From: Anita Gardner <Anita.Gardner@arun.gov.uk>
Sent: 24 February 2021 13:30
To: Planning.Responses <Planning.Responses@arun.gov.uk>
Subject: FW: CM/8/21/PL Climping College, Climping

Please let me have revised details of the bund and trees as soon as possible. Consultations have been undertaken and it would be helpful if comments can be based on the scheme as it is intended rather than as submitted. At this stage I can't advise if the application would require re-advertising, but it is a possibility.

Clymping Mill
Climping Street
Climping BN17 5RN

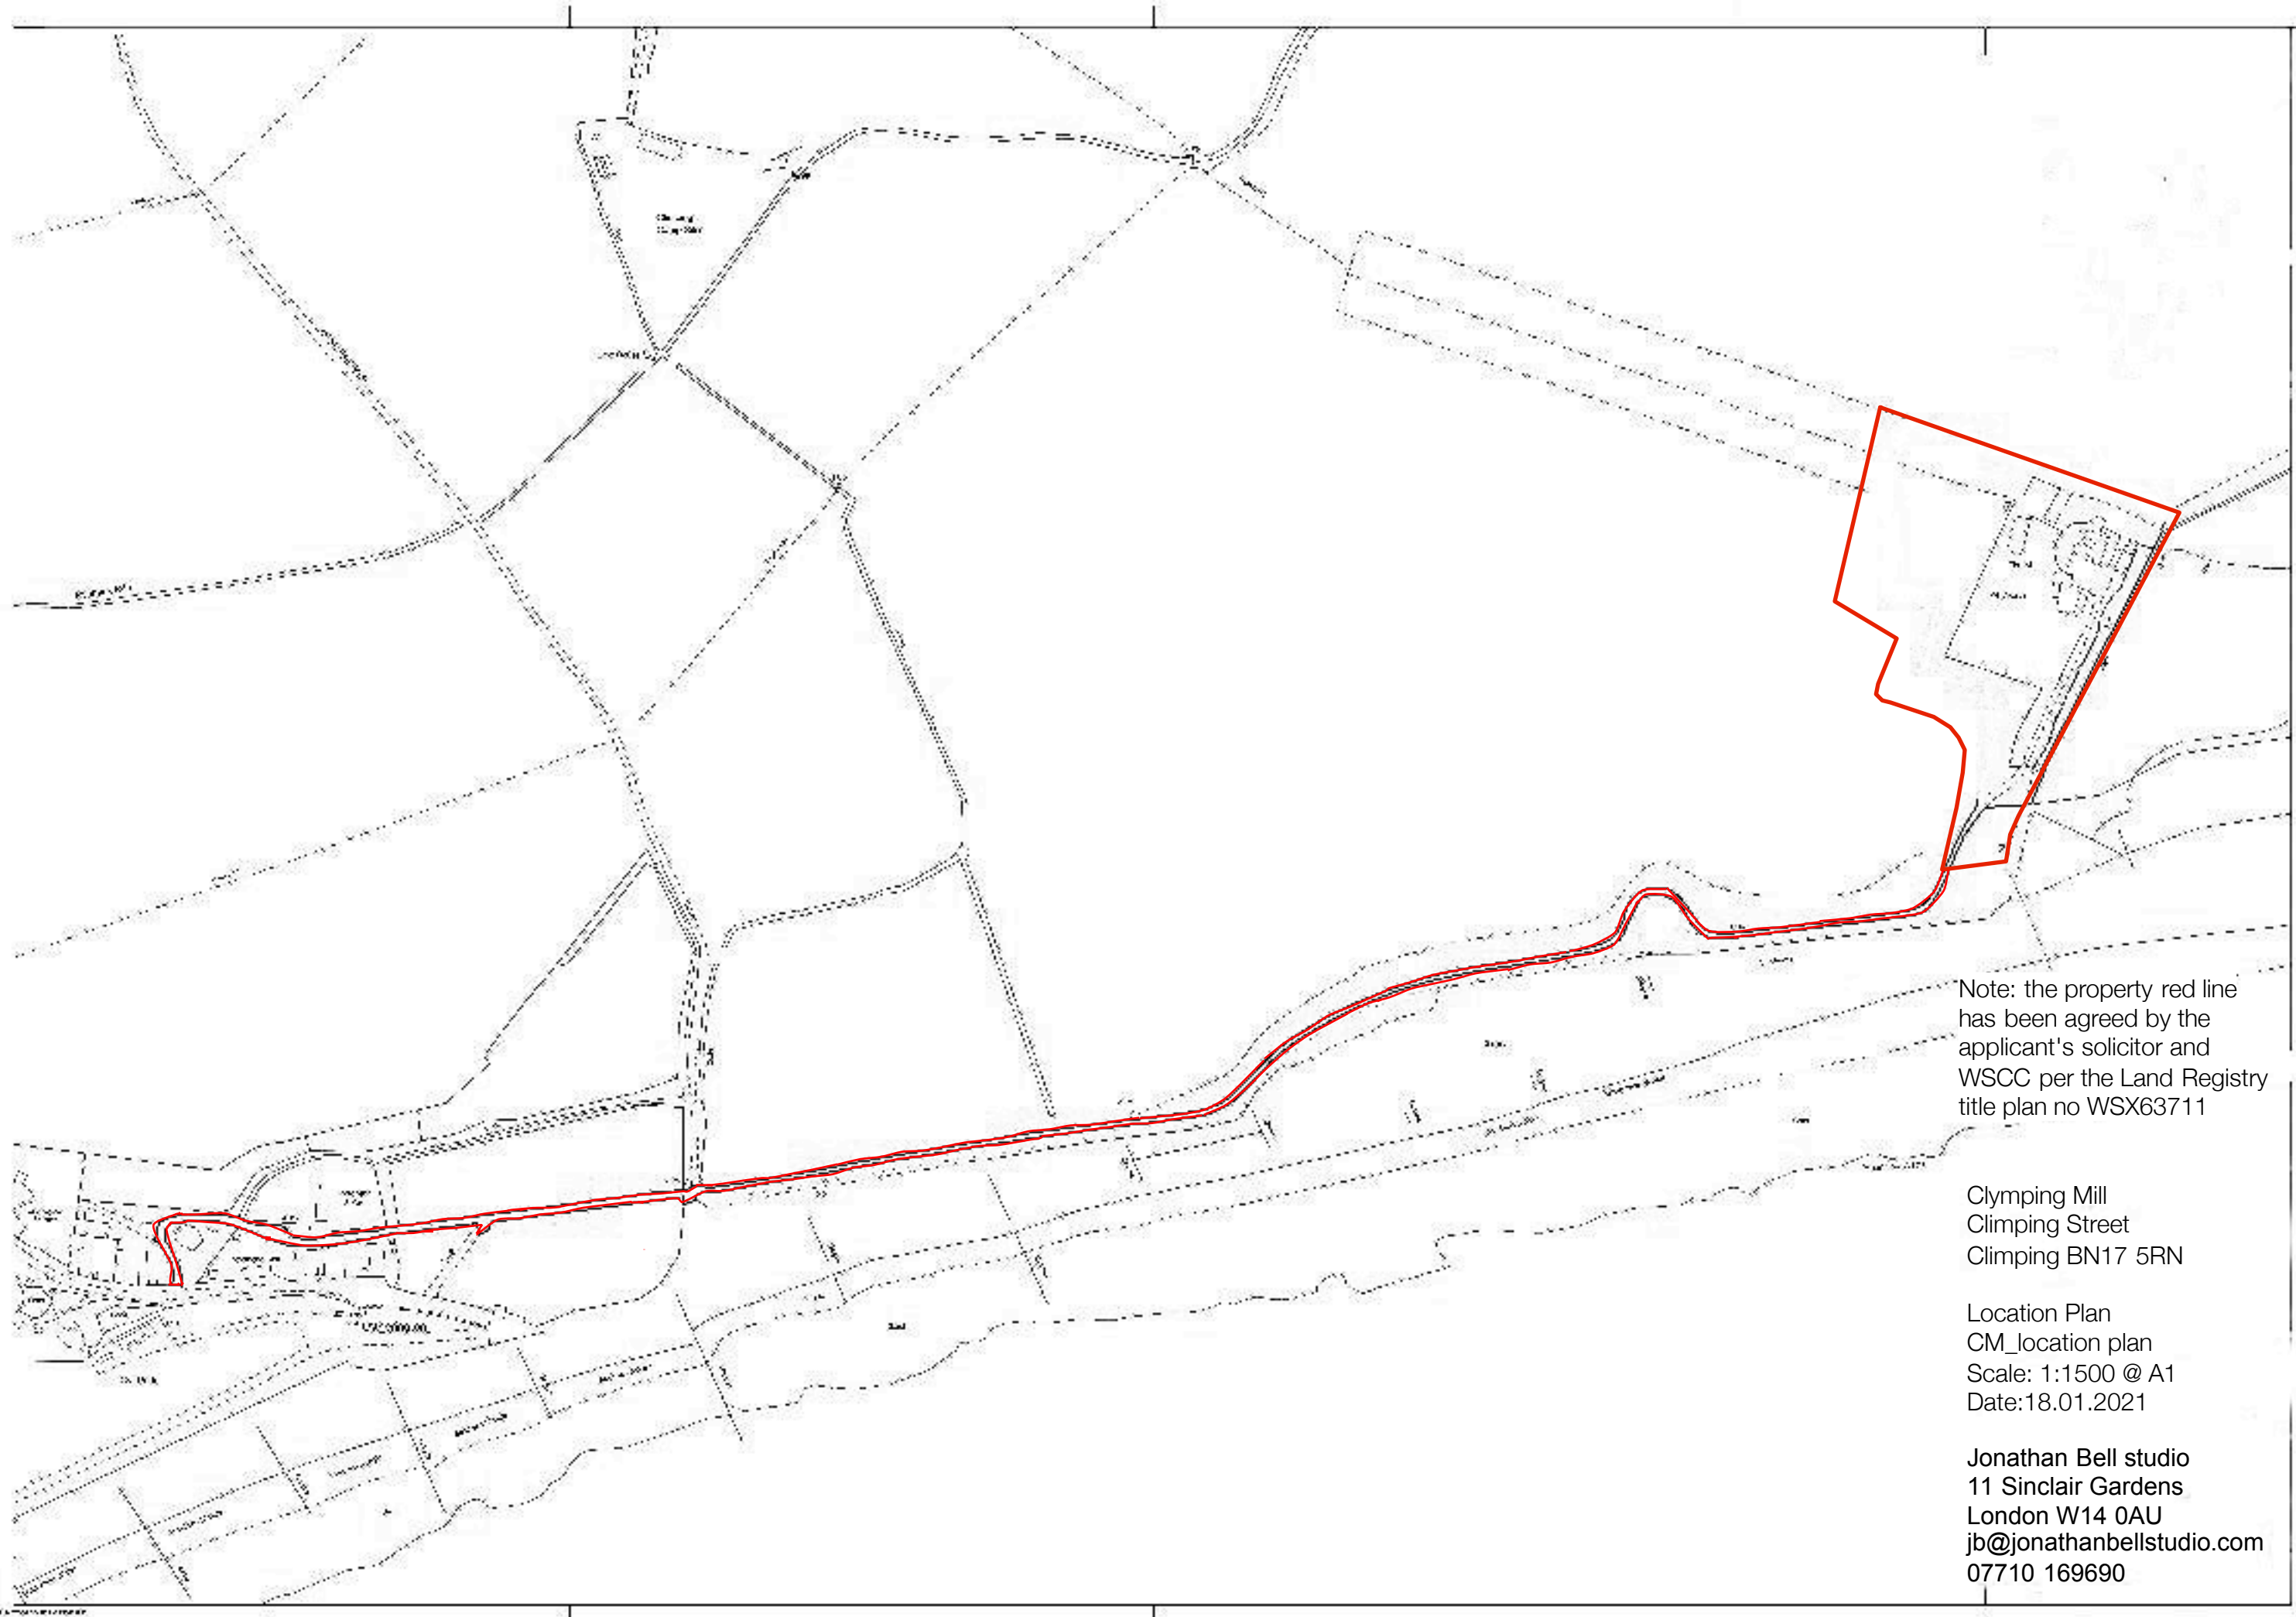
The red edge needs extending because all applications submitted are required to include access to a public highway within the red edge of an application site.

I have just spoken to Anita Gardner, the case officer. I am putting your application on hold as she has requested the Location Plan needs to have the red edge to the main highway (as on CM/25/20/PL...you can see this on our website).
